Fwd: 415 Cumberland ave Permit invoice

I received some feedback from Tom Errico, our third-party traffic engineer, regarding the Construction Management Plan (CMP) draft you provided. Currently, it is not acceptable and will need to be revised to reflect the following feedback.

Drawing file: 8. Construction Management Plans / Construction Managment Plan_06-16-18.pdf

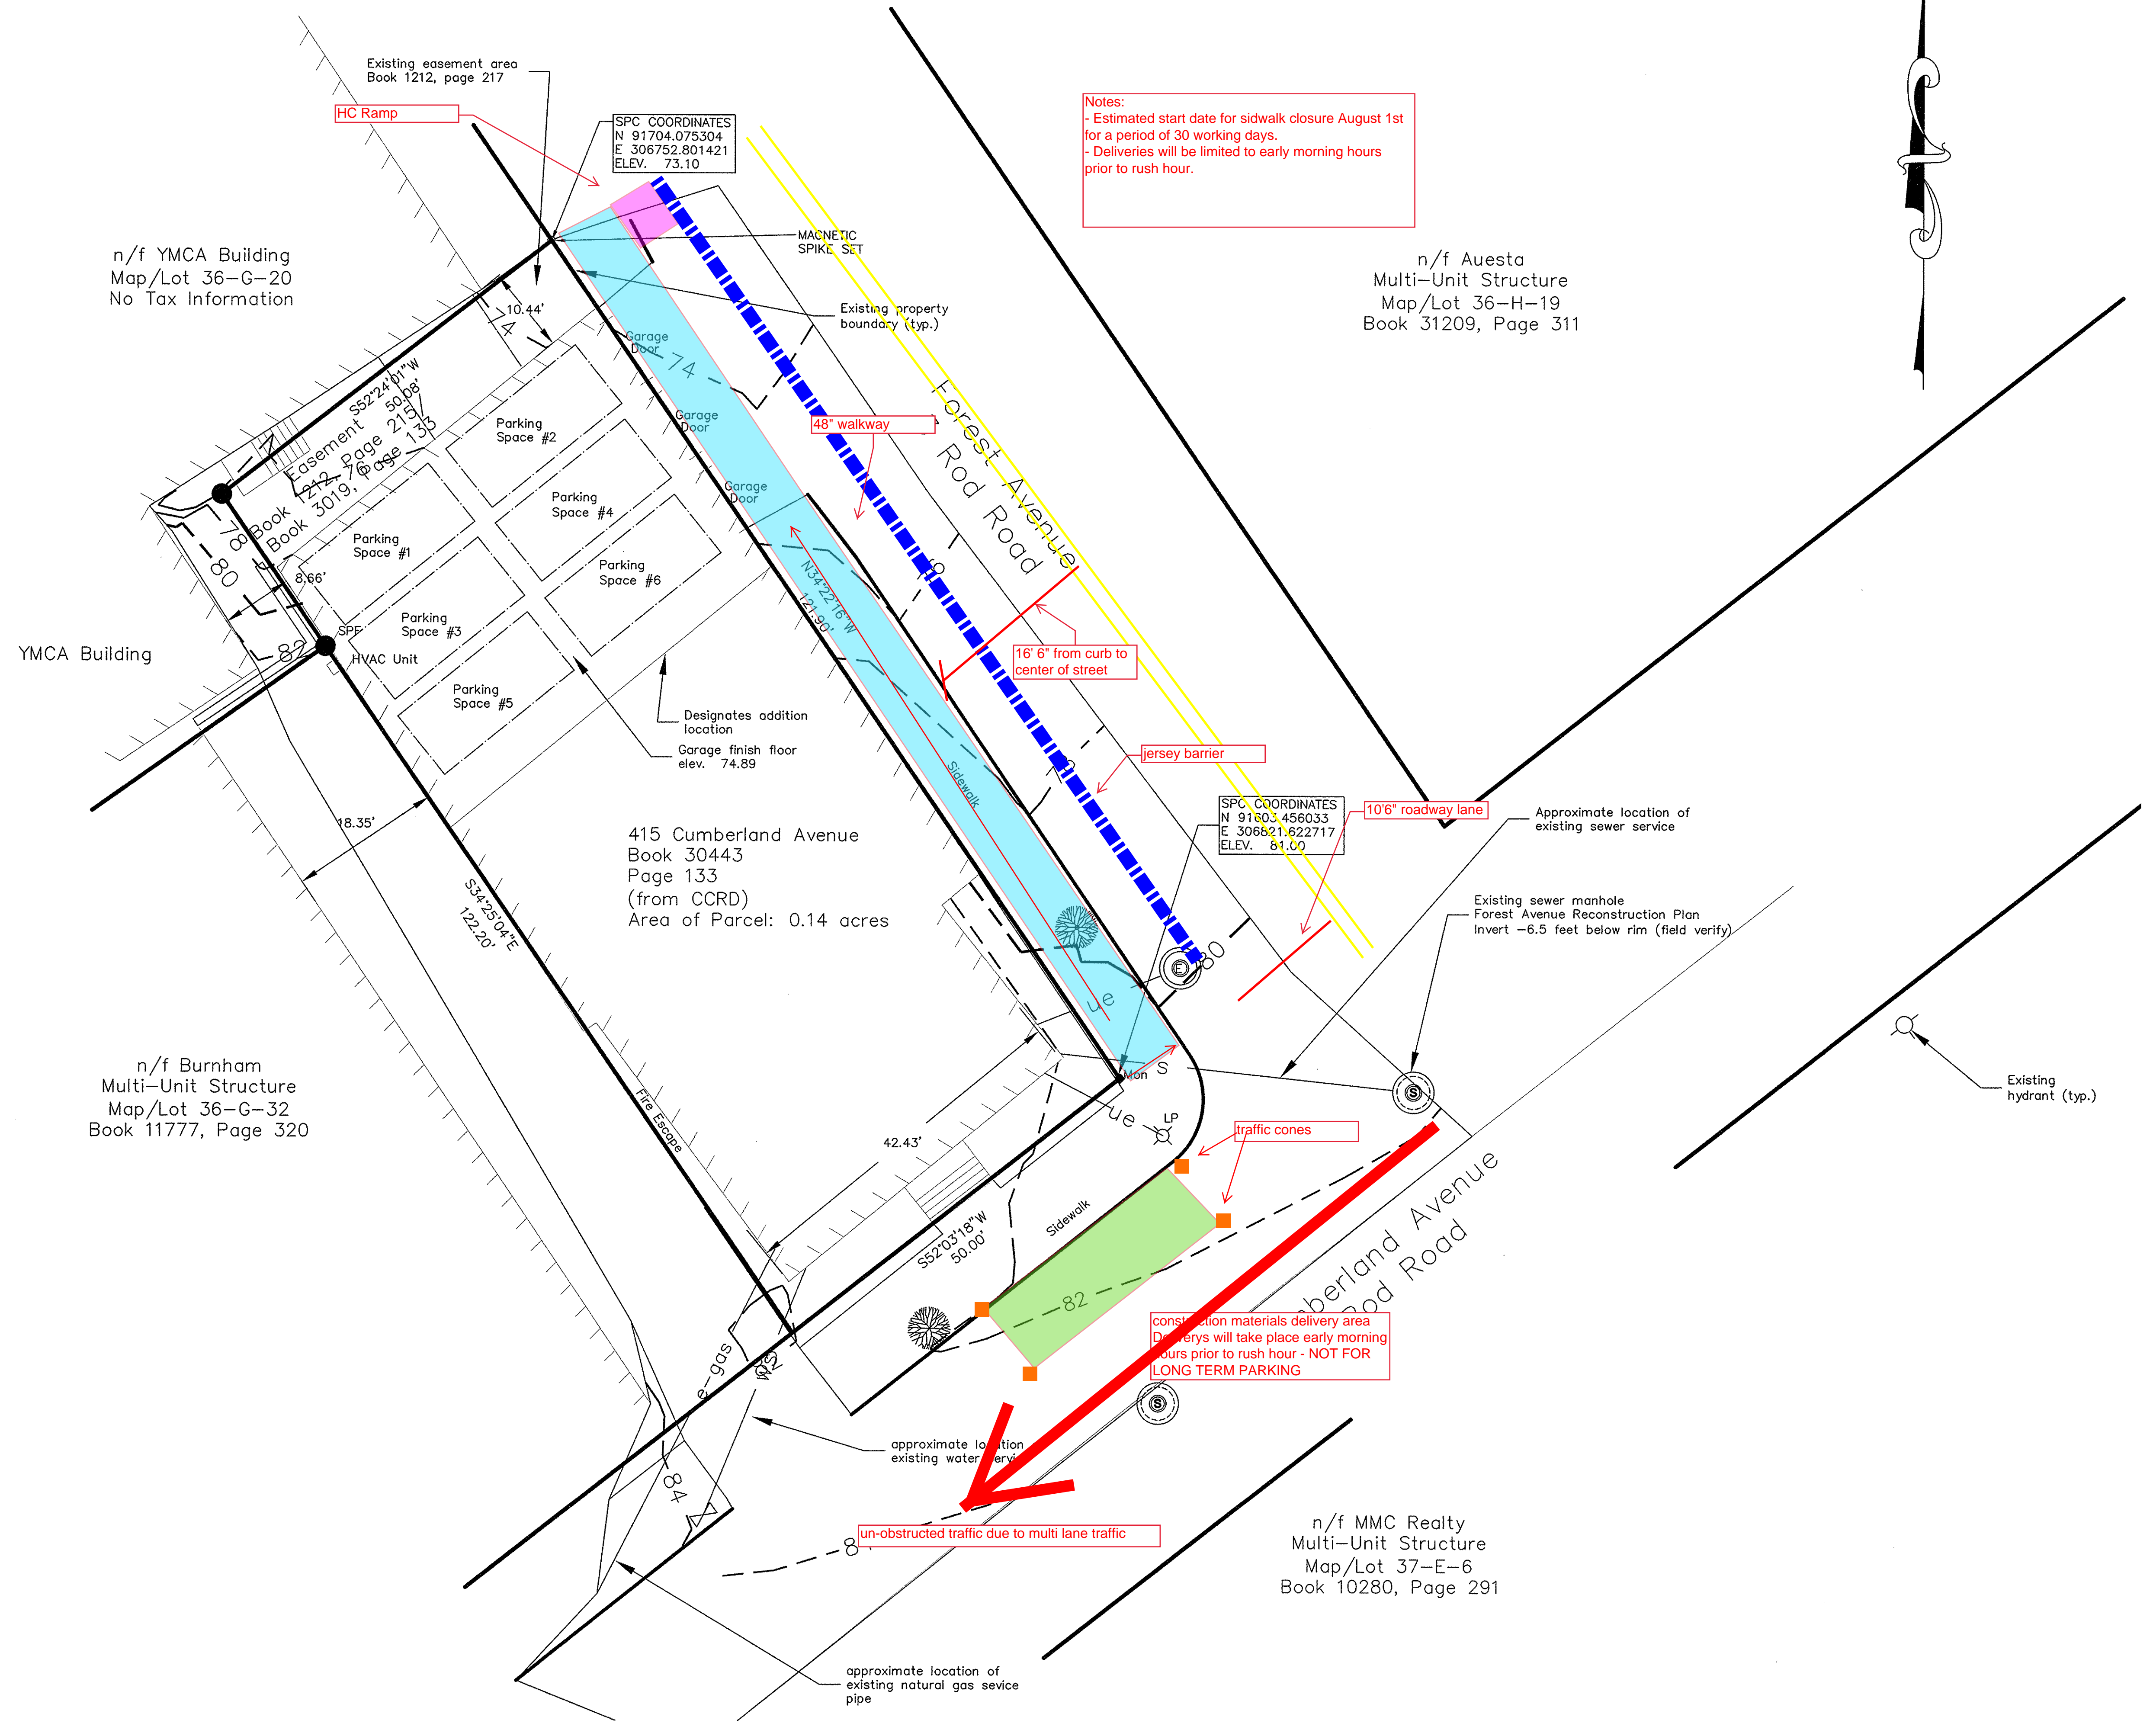
- Temporary detour routes need to be ADA compliant and make sense from a use perspective. If it can fit, it may make sense to provide a temporary facility with a barrier.
- The scope and duration of the sidewalk closure should be defined and noted on the plan. DPW does not support the occupancy of a sidewalk for an extended period of time and construction sequences shall be scheduled to minimize the duration of any occupancy.
- DPW does not support the occupancy of a parking space for an extended period of time. Construction sequences shall be scheduled to minimize the duration of any occupancy. This should be noted on the plan.
- Roadway width dimensions for the vehicle loading area on Cumberland Avenue should be provided on the plan.

To be clear, please know that I remember / understand the current condition of the sidewalk, but as there is more to ADA compliance than just sidewalk surface please address / note / plan for these items on the CMP as it relates to any pedestrian detour. I also know that you mentioned in your email you plan on limited sidewalk occupancy - please note the specific duration / phasing / details on the plan so that is clear. Please feel free to reach out with any questions, and as soon as you have an updated CMP reflecting the above feedback I'll be happy to send it back out for review.
